August 22, 2019

**Re: Academy Dental Center**  
**6421 Holly Ave NE**  
**Traffic Circulation Layout**  
Engineer's/Architect's Stamp 08-20-2019 (C18D038A)

Based upon the information provided in your submittal received 08-20-2019, the above referenced plan cannot be approved for Building Permit until the following comments are addressed:

Site Plan

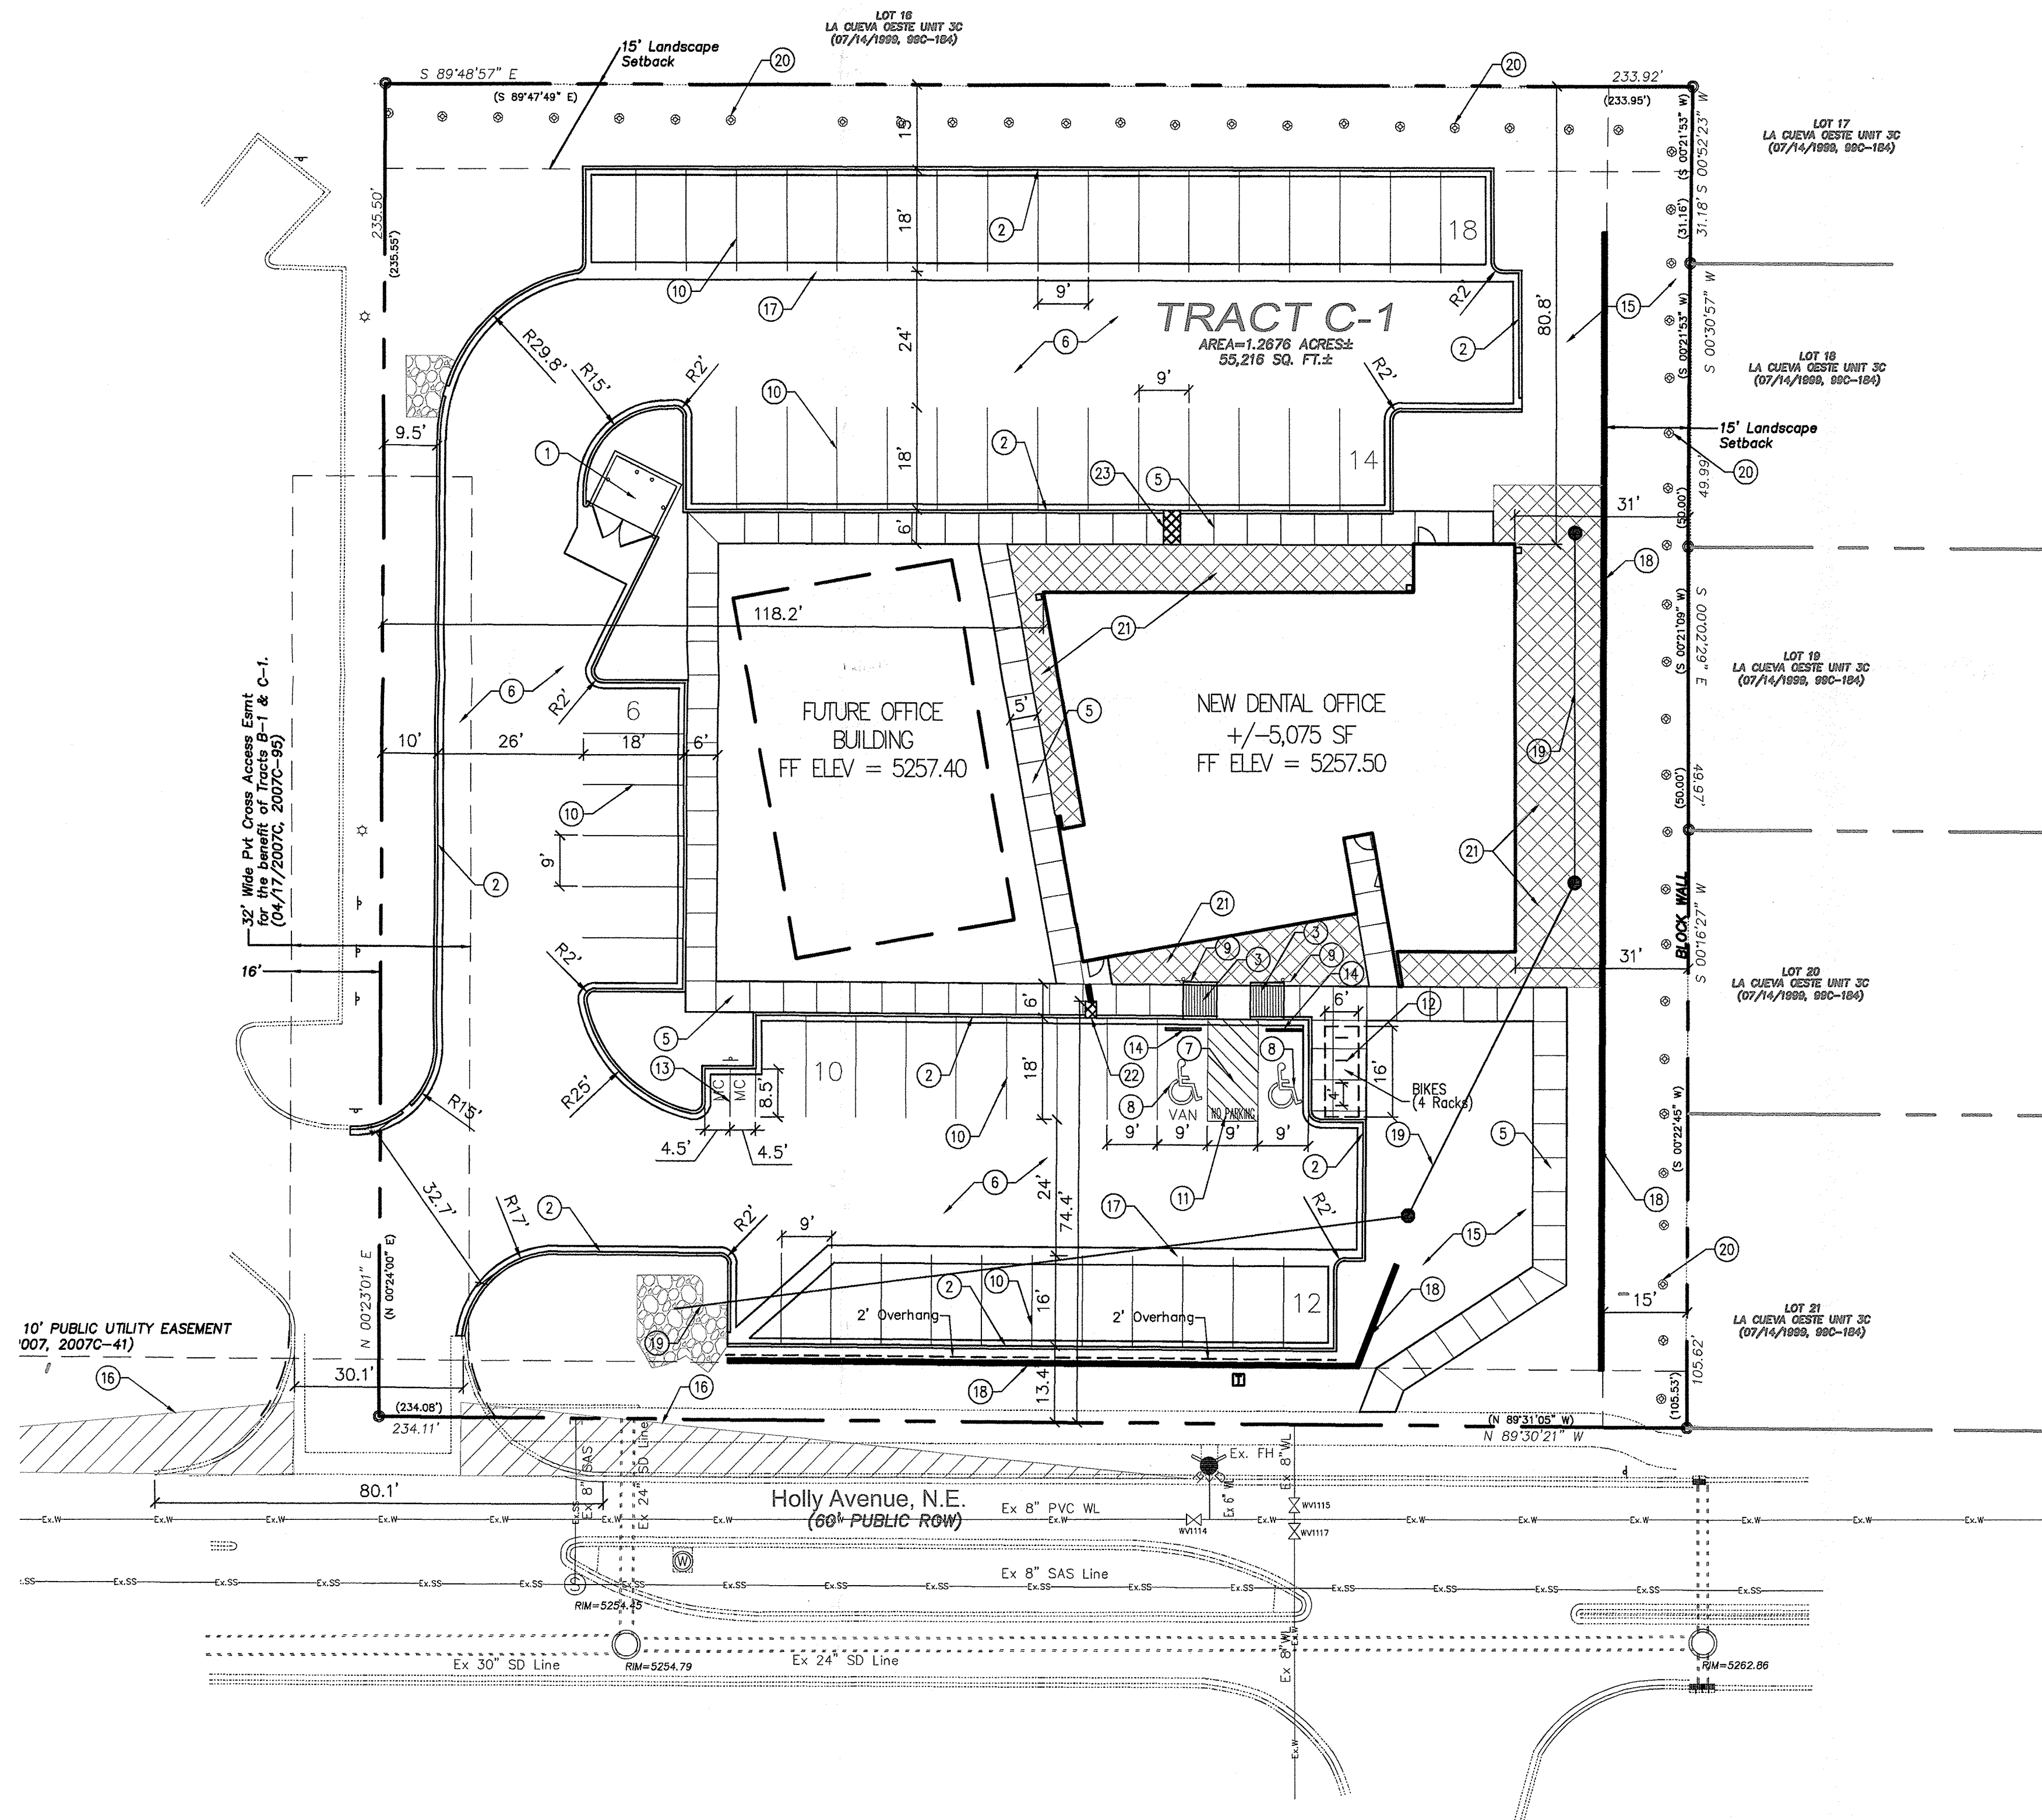
1. Identify all existing access easements.
2. The ADA accessible parking sign must have the required language per 66-7-352.4C NMSA 1978 **"Violators Are Subject to a Fine and/or Towing."** Please call out detail and location of signs.

3. Motorcycle parking spaces shall be designated by its own conspicuously posted upright sign, either free-standing or wall mounted per the zoning code.

8. Show the entrance dimension
9. provide a copy of refuse approval.
10. Shared Site acces: driveways that straddle property lines, or are entirely on one propertybut are to be used by another property, shall have an access easement.

Please include a copy of your shared access agreement with the adjacent property owner.

Site Details

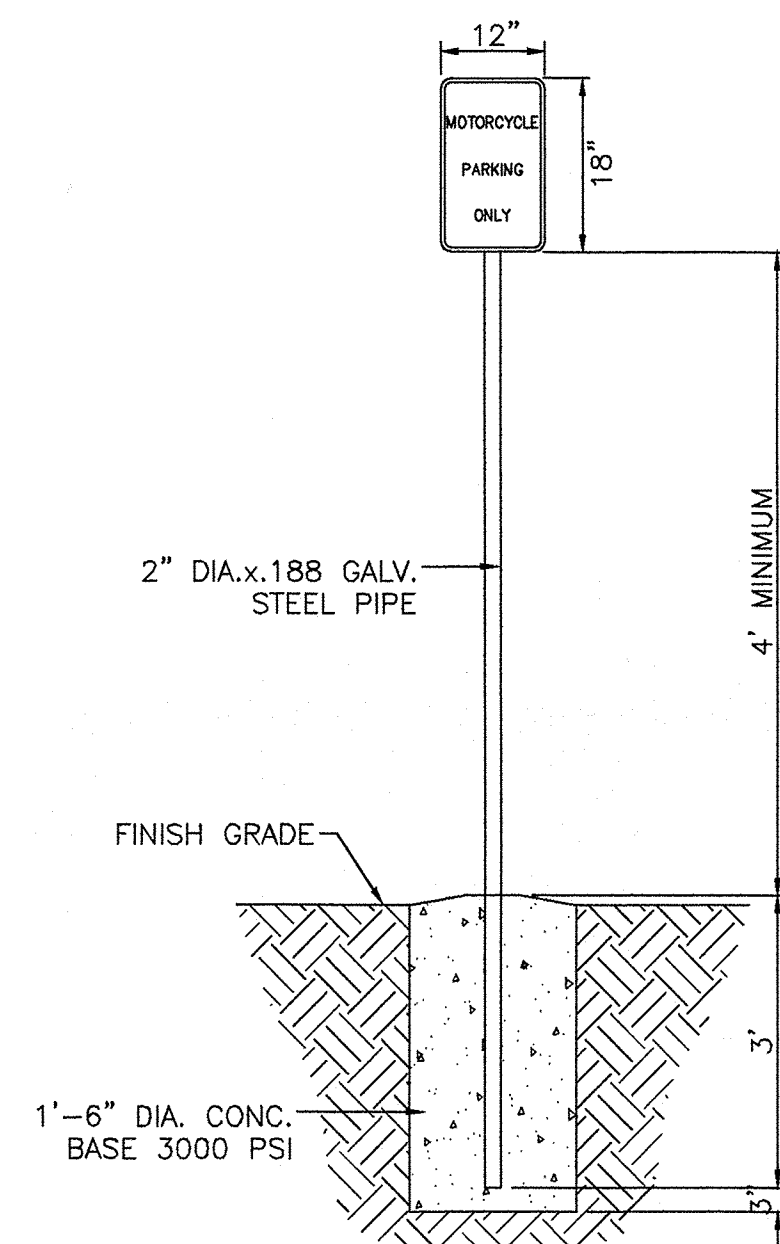
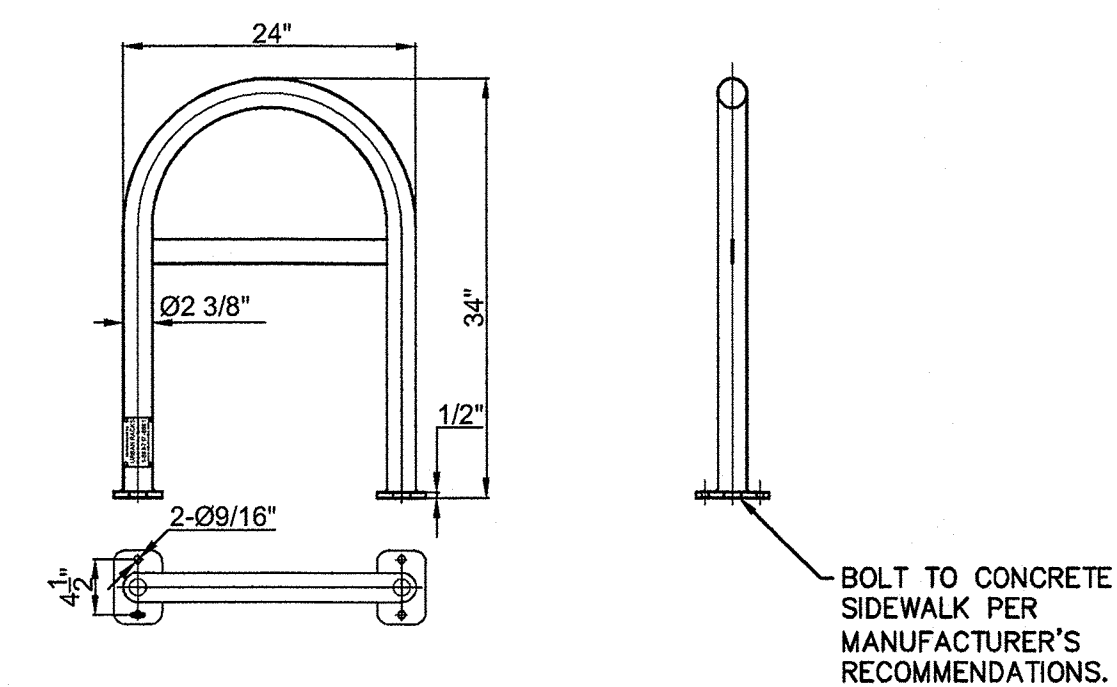
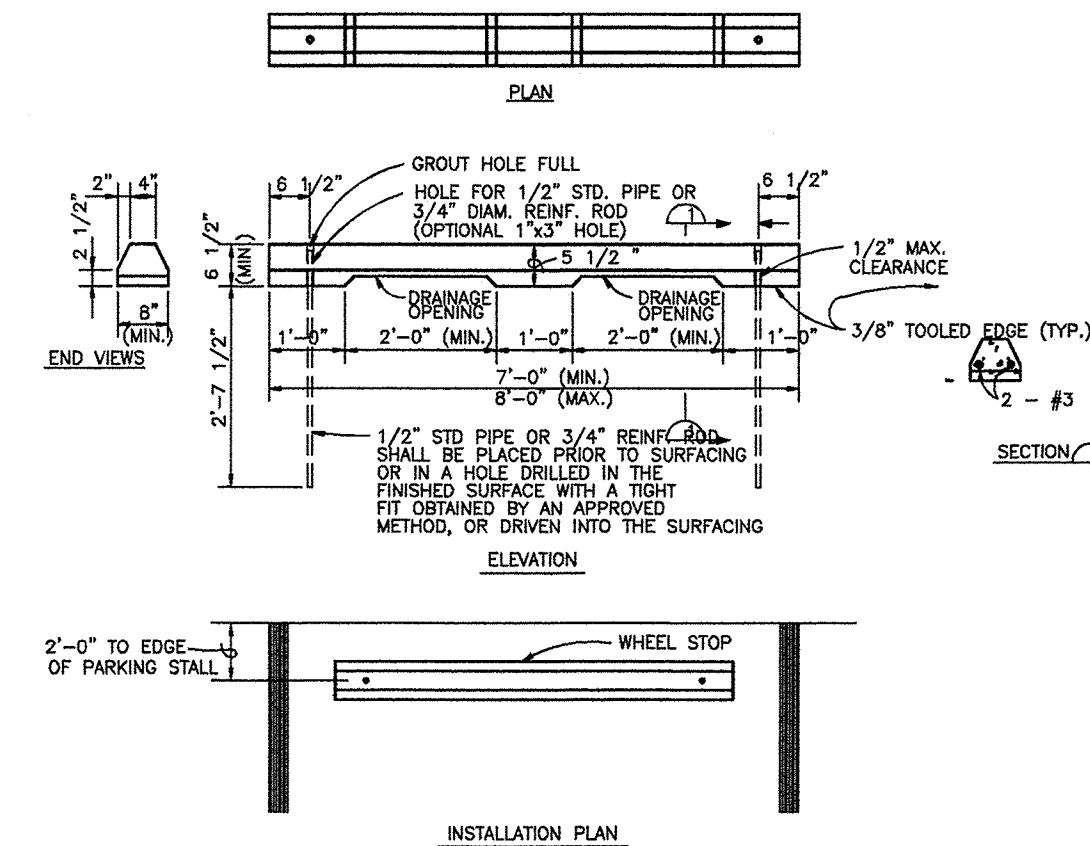
4. All bicycle racks shall be designed according to the following guidelines:
  - a. The rack shall be a minimum 30 inches tall and 18 inches wide.
  - b. The bicycle frame shall be supported horizontally at two or more places. Comb/toaster racks are not allowed.

- c. The rack shall be designed to support the bicycle in an upright position. See the IDO for additional information.
  - d. The rack allows varying bicycle frame sizes and styles to be attached.

- e. The user is not required to lift the bicycle onto the bicycle rack.
  - f. Each bicycle parking space is accessible without moving another bicycle.

5. Bicycle racks shall be sturdy and anchored to a concrete pad.
6. A 1-foot clear zone around the bicycle parking stall shall be provided.
7. Bicycle parking spaces shall be at least 6 feet long and 2 feet wide.
